**From:** Carol Reynolds  
**Sent:** 25 May 2017 11:08  
**To:** Planning.Responses  
**Subject:** FW: Planning Consultation on: LU/121/17/RES

**Environmental Health:** I refer to the Acoustic Assessment prepared by WYG, March 2017: Reserved Matters Application (Phase 2) and Discharge of Conditions, North Littlehampton. The report provides insufficient detail for agreement to discharge of conditions 37 & 38. Specifically, Para 6 Mitigation.

**APPLICATION** LU/121/17/RES

**Description of Works:** Approval of reserved matters following outline consent  
LU/47/11/ for construction of 126 No. dwellings together with  
internal road network, car parking & landscaping.

Drawing Title:	
Site Layout - INFORMATION	
Drawing Status:	Drawn:
SUBMITTED	KJ
	Rev:
	-

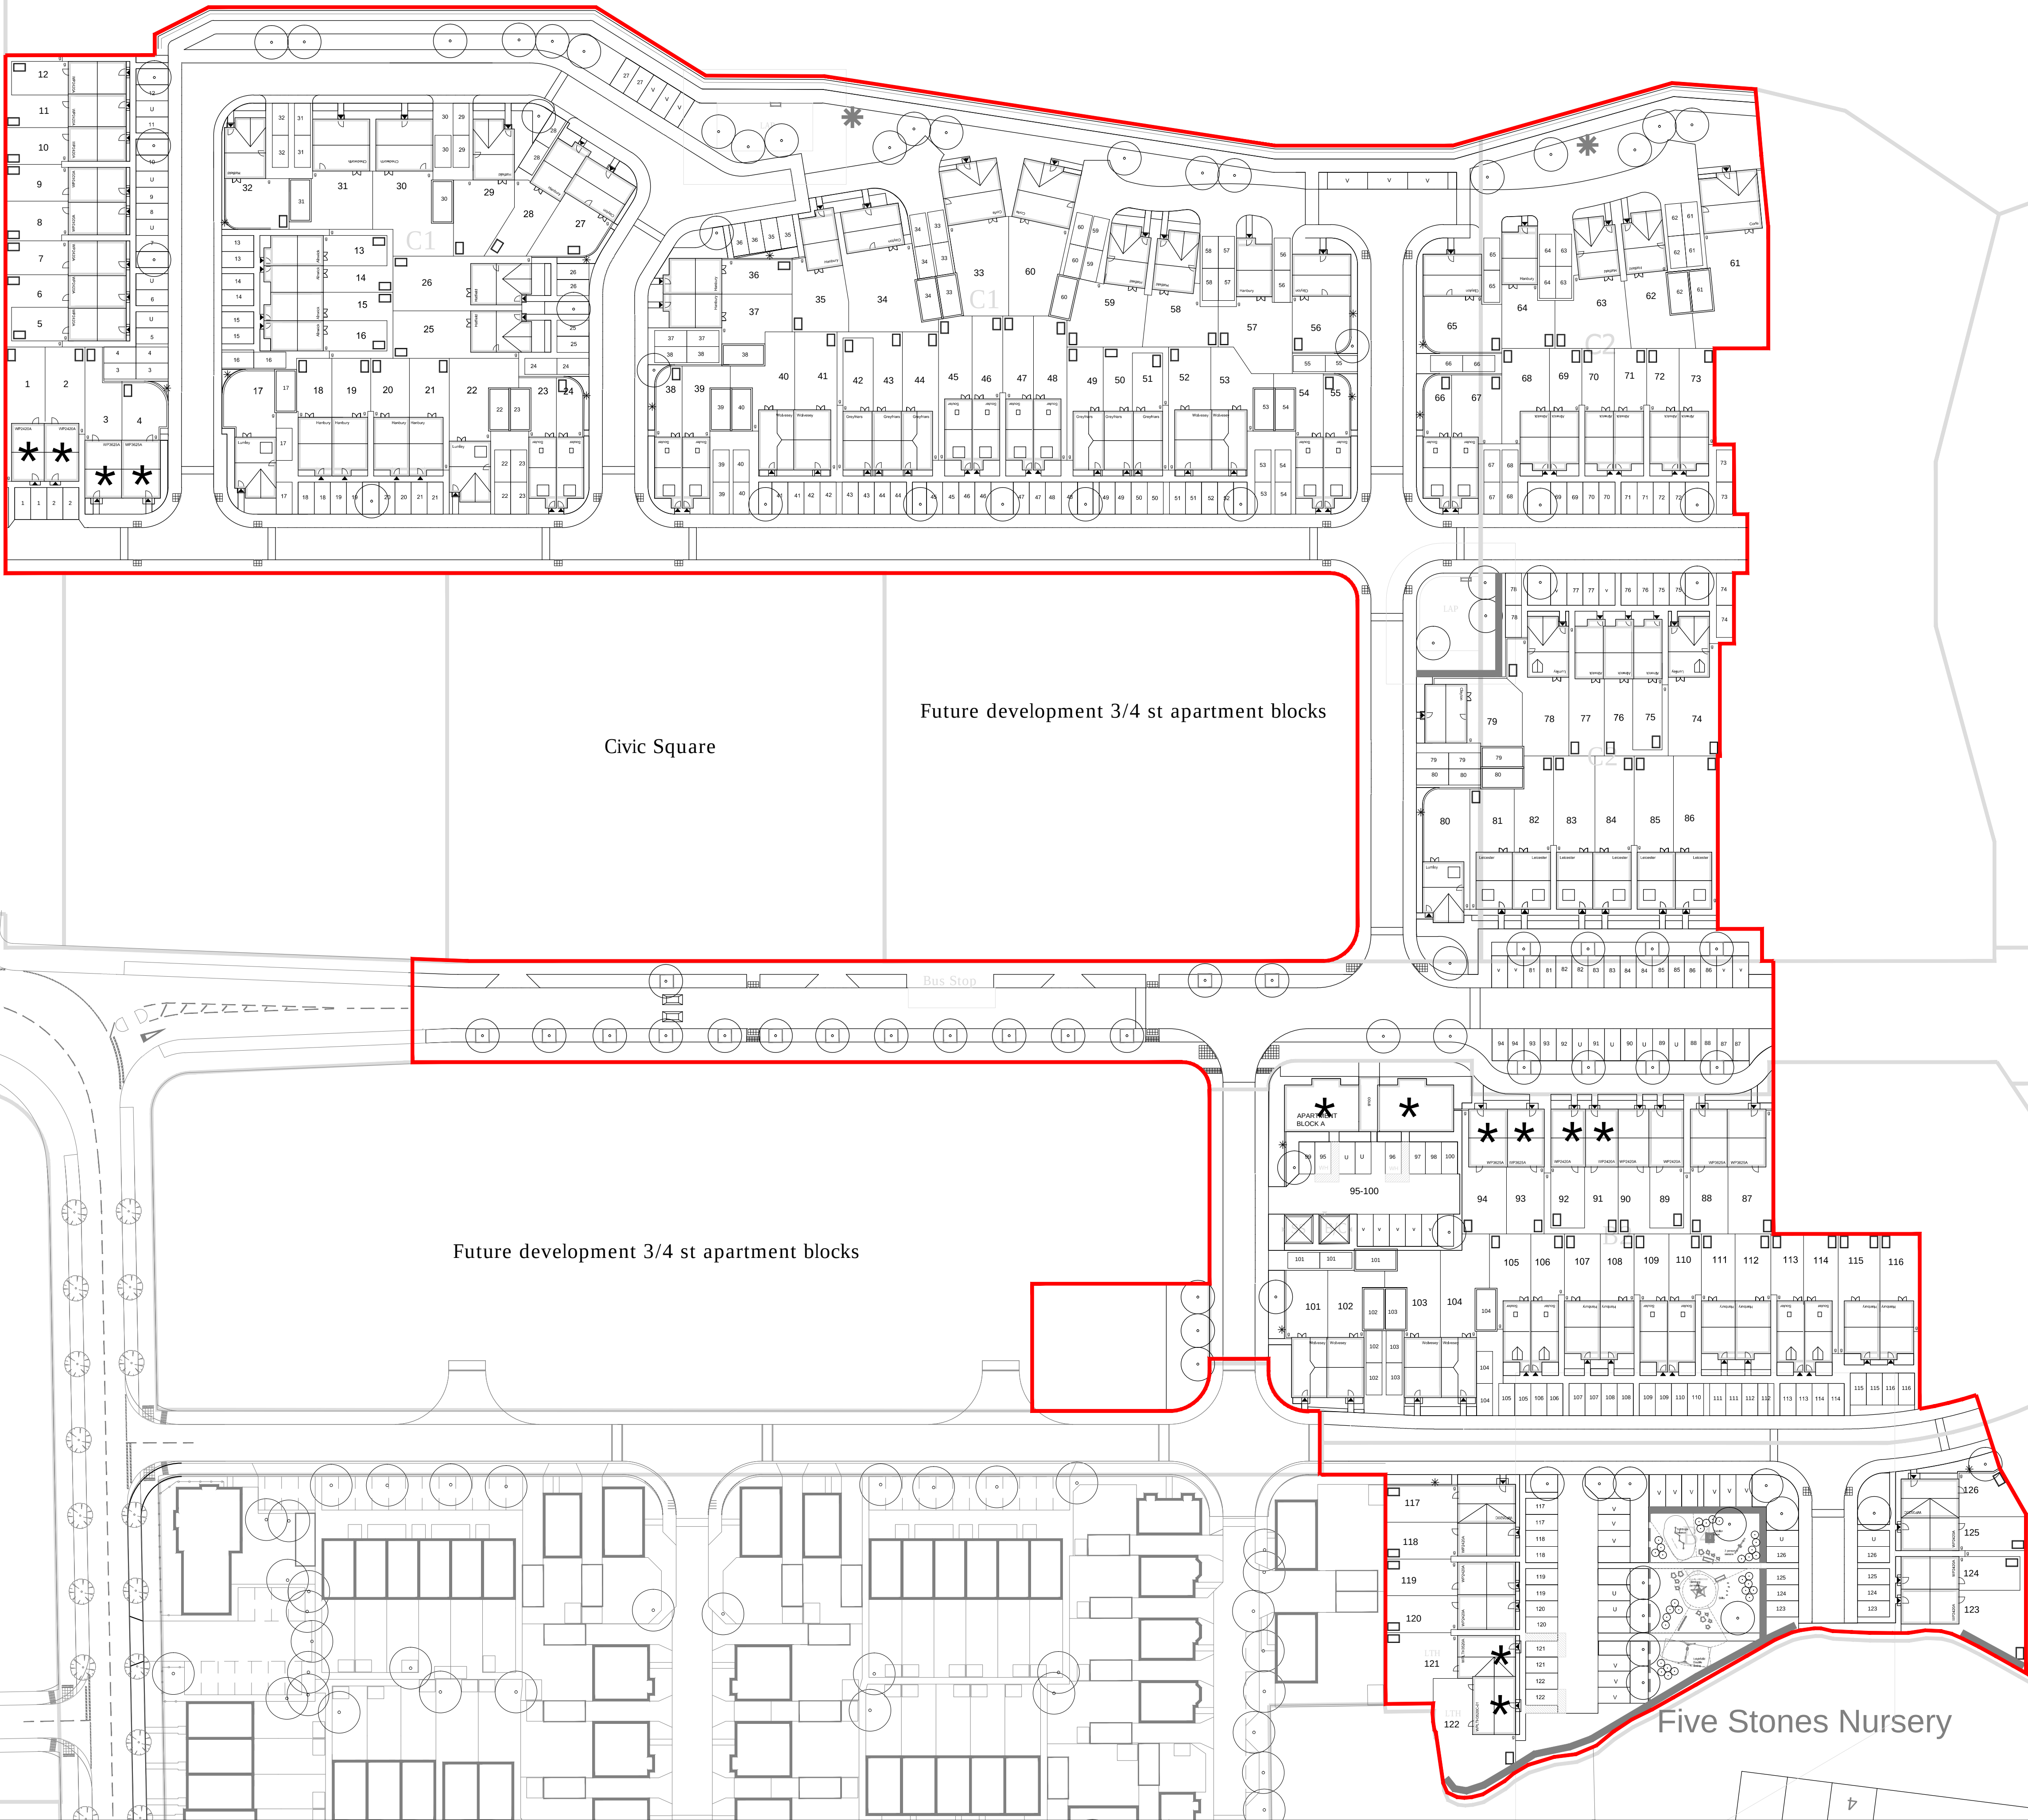
\*Fencing. Please provide detail of where acoustic fences will be positioned in order to achieve the desired mitigation. Please also provide detail of proposed acoustic fencing specification.

SK02 Site Layout and Receptor Locations

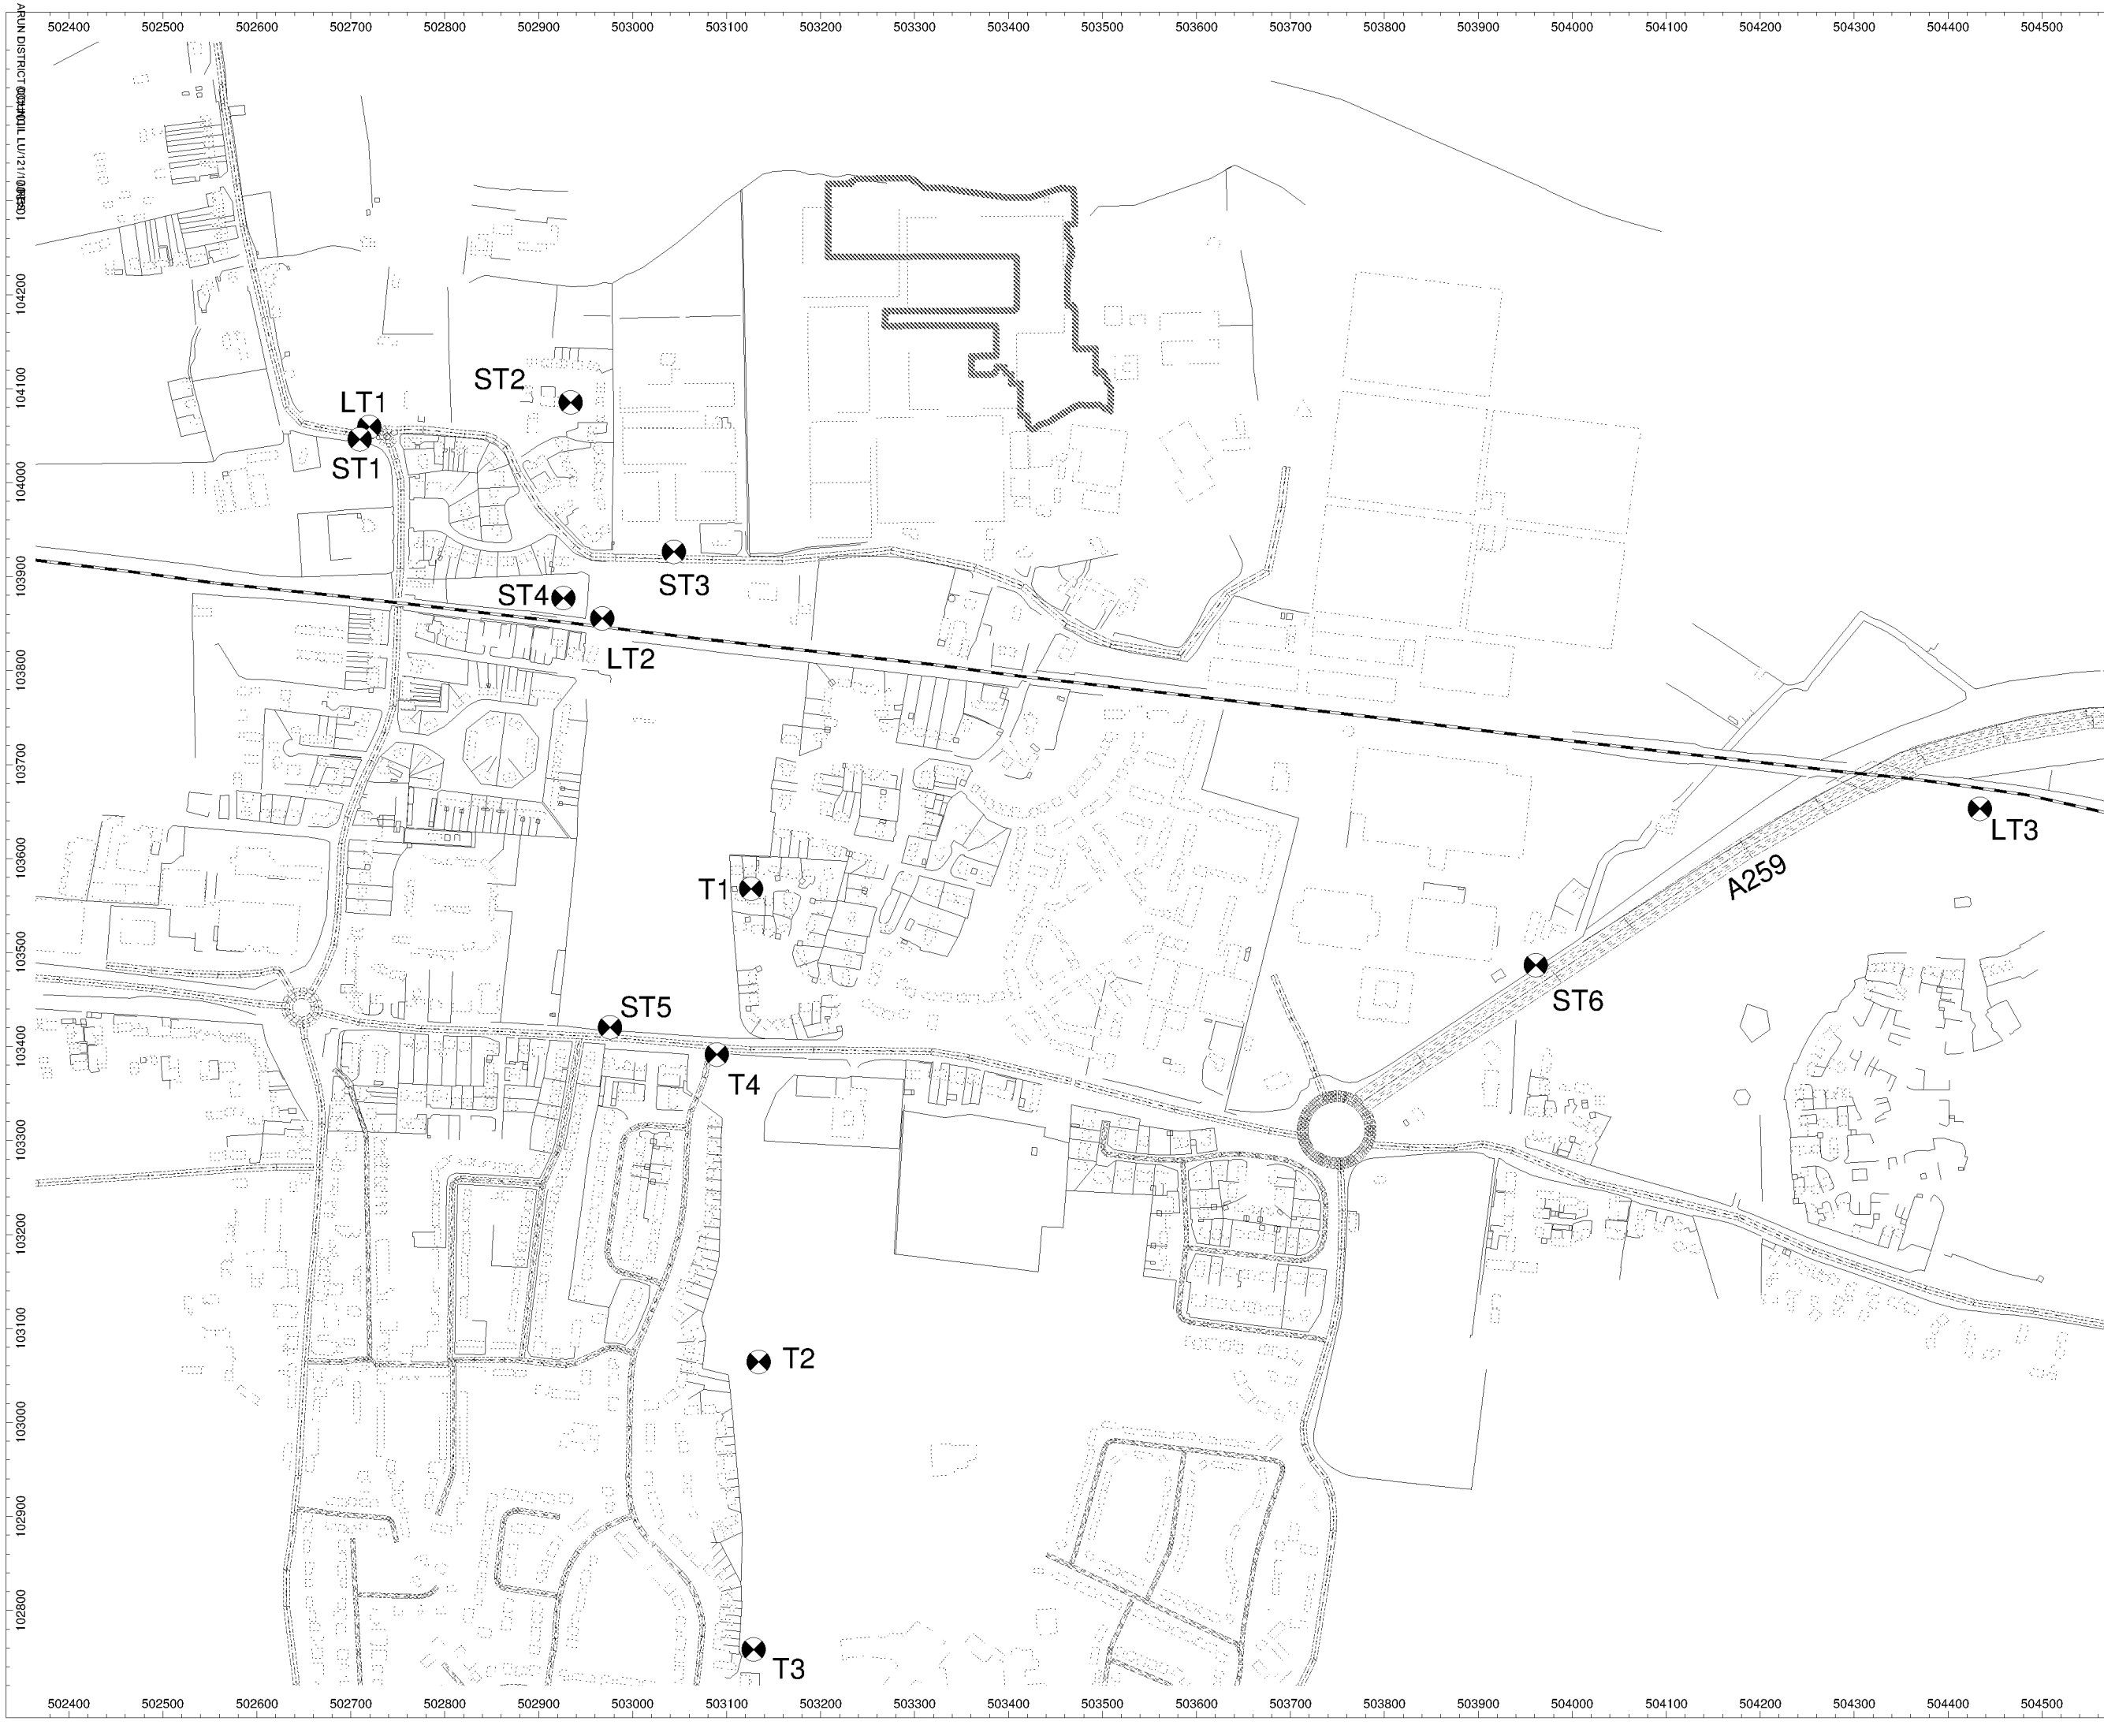
\*'Building Design and Layout' Please provide the agreed layout of buildings and position of noise sensitive rooms within these in relation to the main sources of noise ie roads, in order to demonstrate the way in which building orientation and internal arrangement have been designed to reduce external noise impact.
